**From:** [Rachael Stevie \(CD\)](#)  
**To:** [Holly Erdman](#)  
**Subject:** FW: BL-21-00014 Frosty Pines - Deemed Complete  
**Date:** Tuesday, June 22, 2021 9:47:00 AM  
**Attachments:** [image001.png](#)  
[image002.png](#)  
[BLA REVIEW DRAFT \(letter size\).pdf](#)  
[BLA REVIEW DRAFT.pdf](#)

**RECORD OF SURVEY
LOTS 3, 7 AND 8, FROSTY PINES**

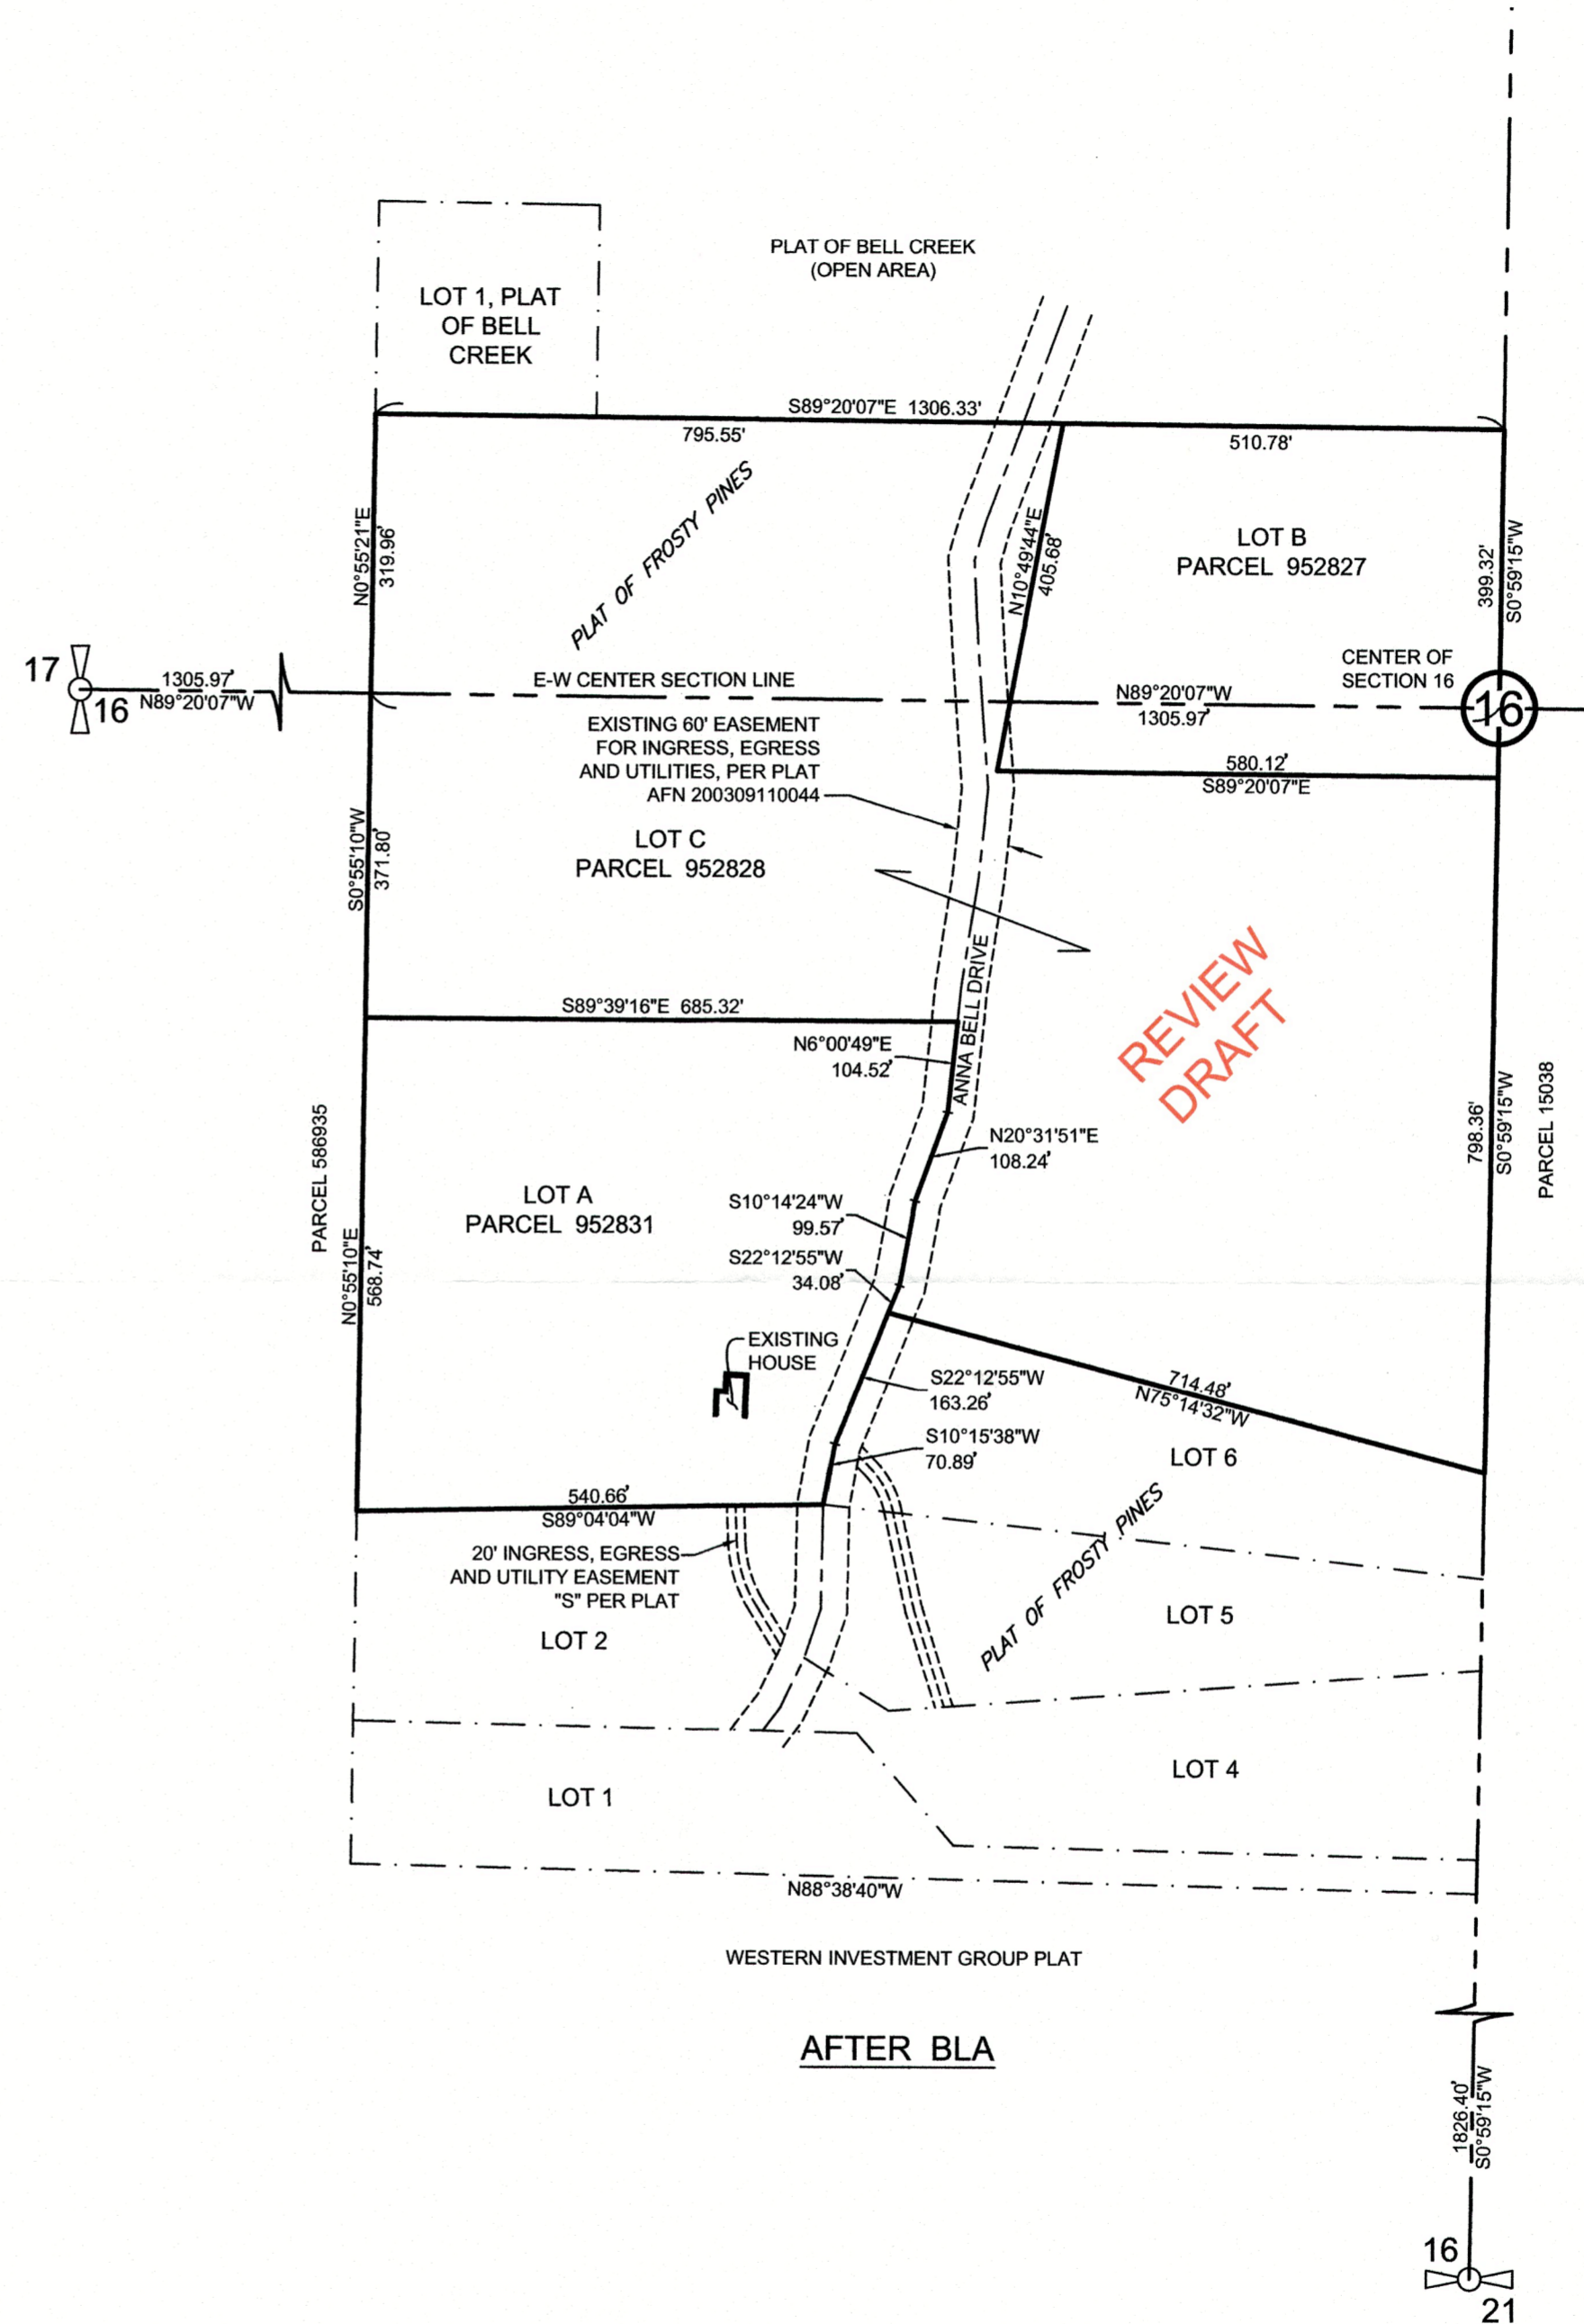
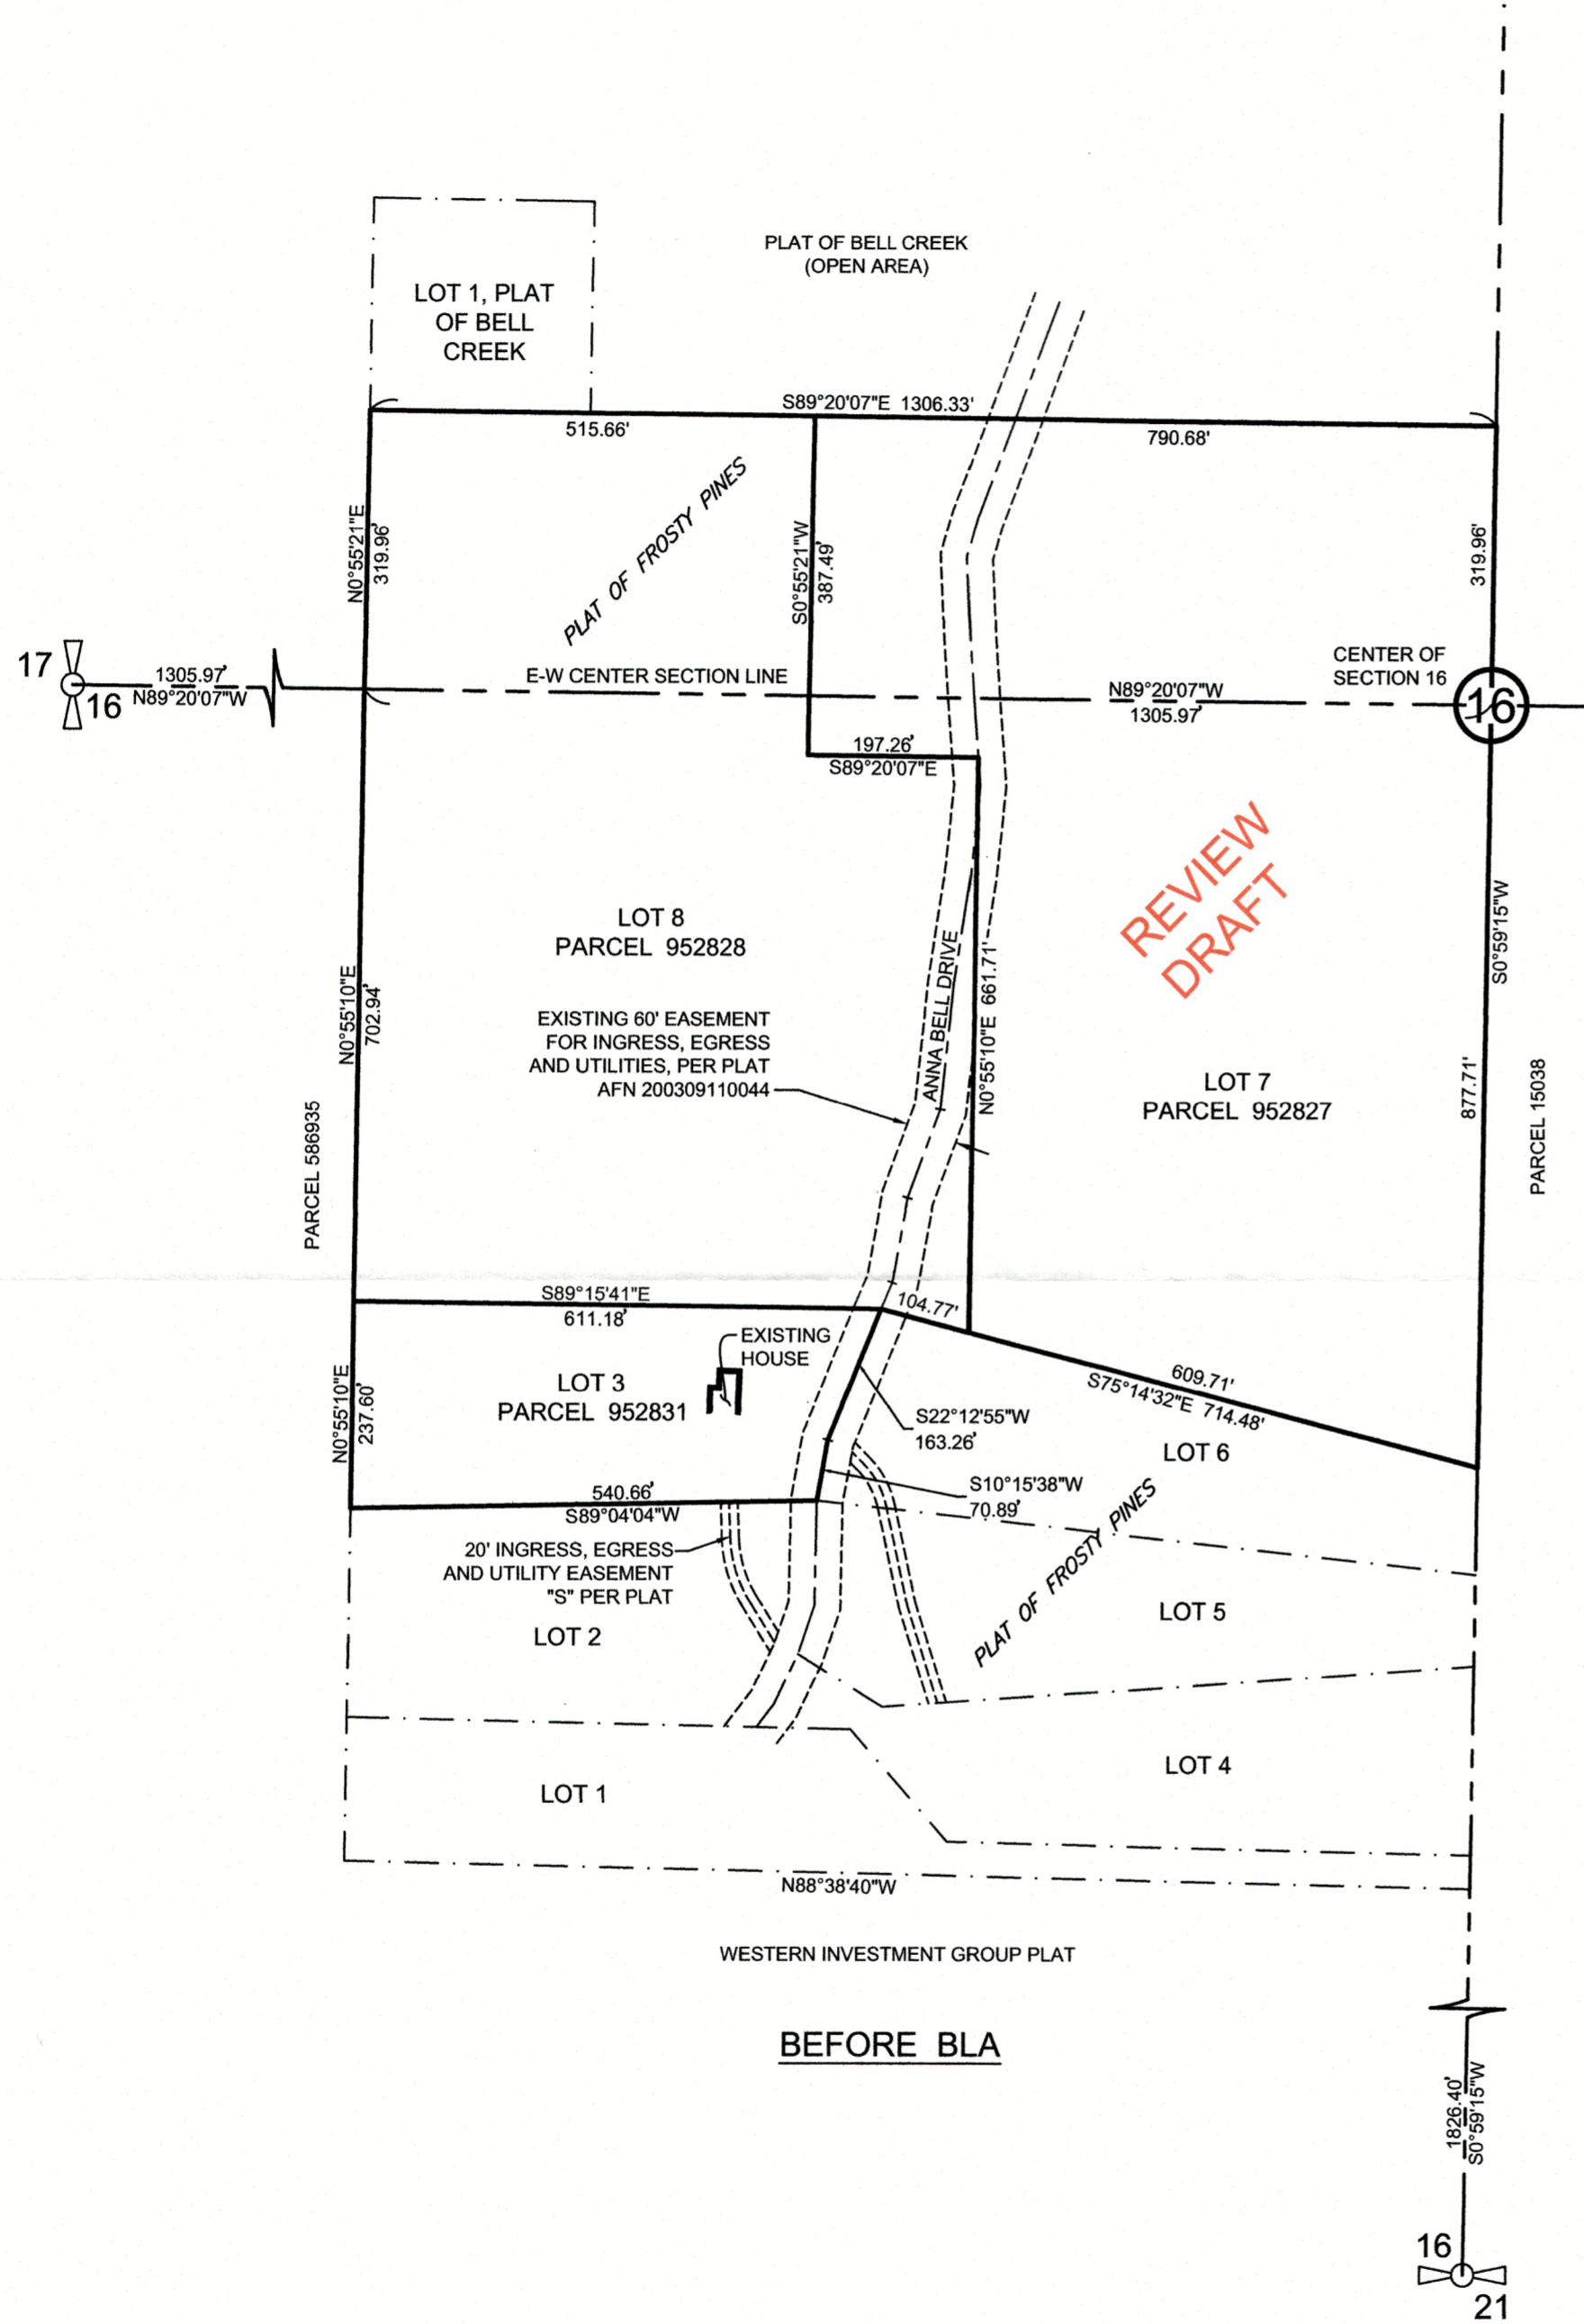
I am also requesting that you provide an updated site map with the location of any well and septic systems identified. I am asking preemptively because I know Public Health will request that information before their review.

Thank you for noticing the well and on-site septic were not shown on the original submittal sheets. Please see attached revised sheets. If you need anything else, please let me know. Enjoy your day!

RECORD OF SURVEY
 LOTS 3, 7 AND 8, FROSTY PINES

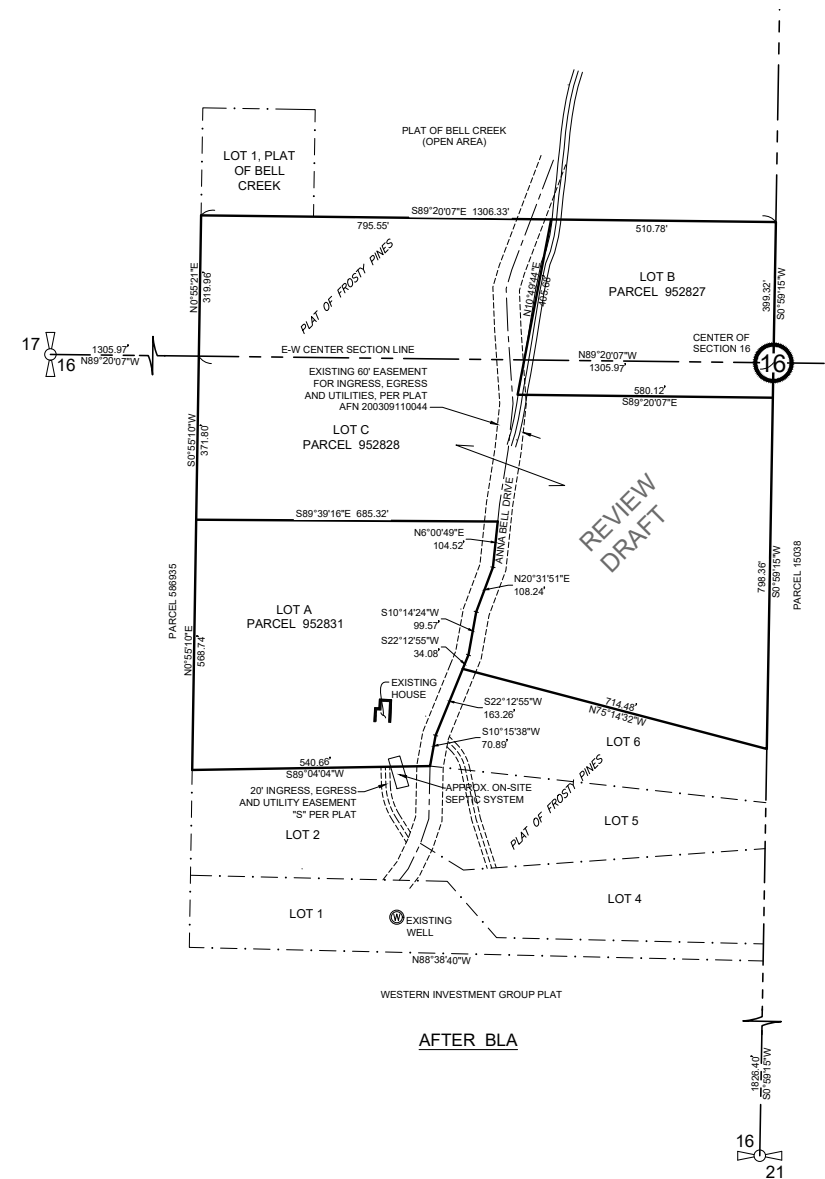
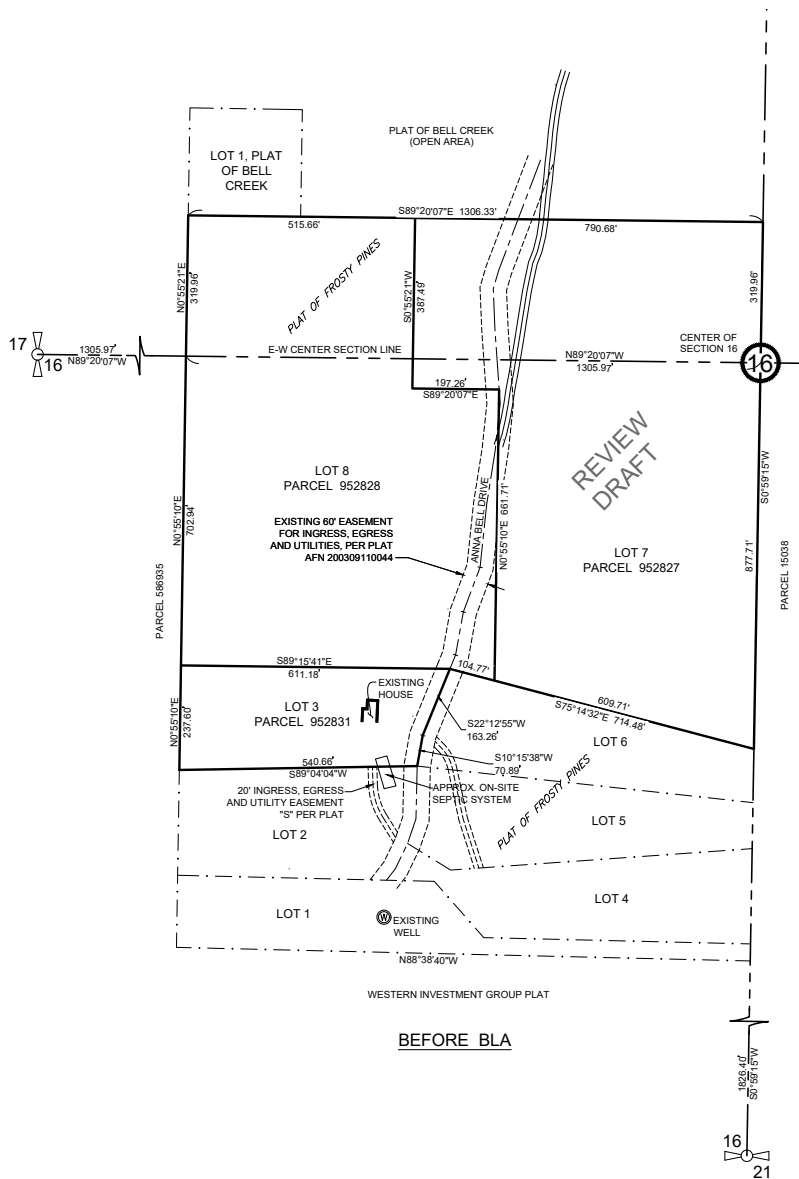
The last site plan I sent you had inaccurate information on the location of the well. Please see updated site plan with the correct well location.

Frost, I have updated the sheets to show the true location of the well servicing the lots involved in the boundary line adjustment. Sorry for any inconvenience this may cause. Enjoy your day!
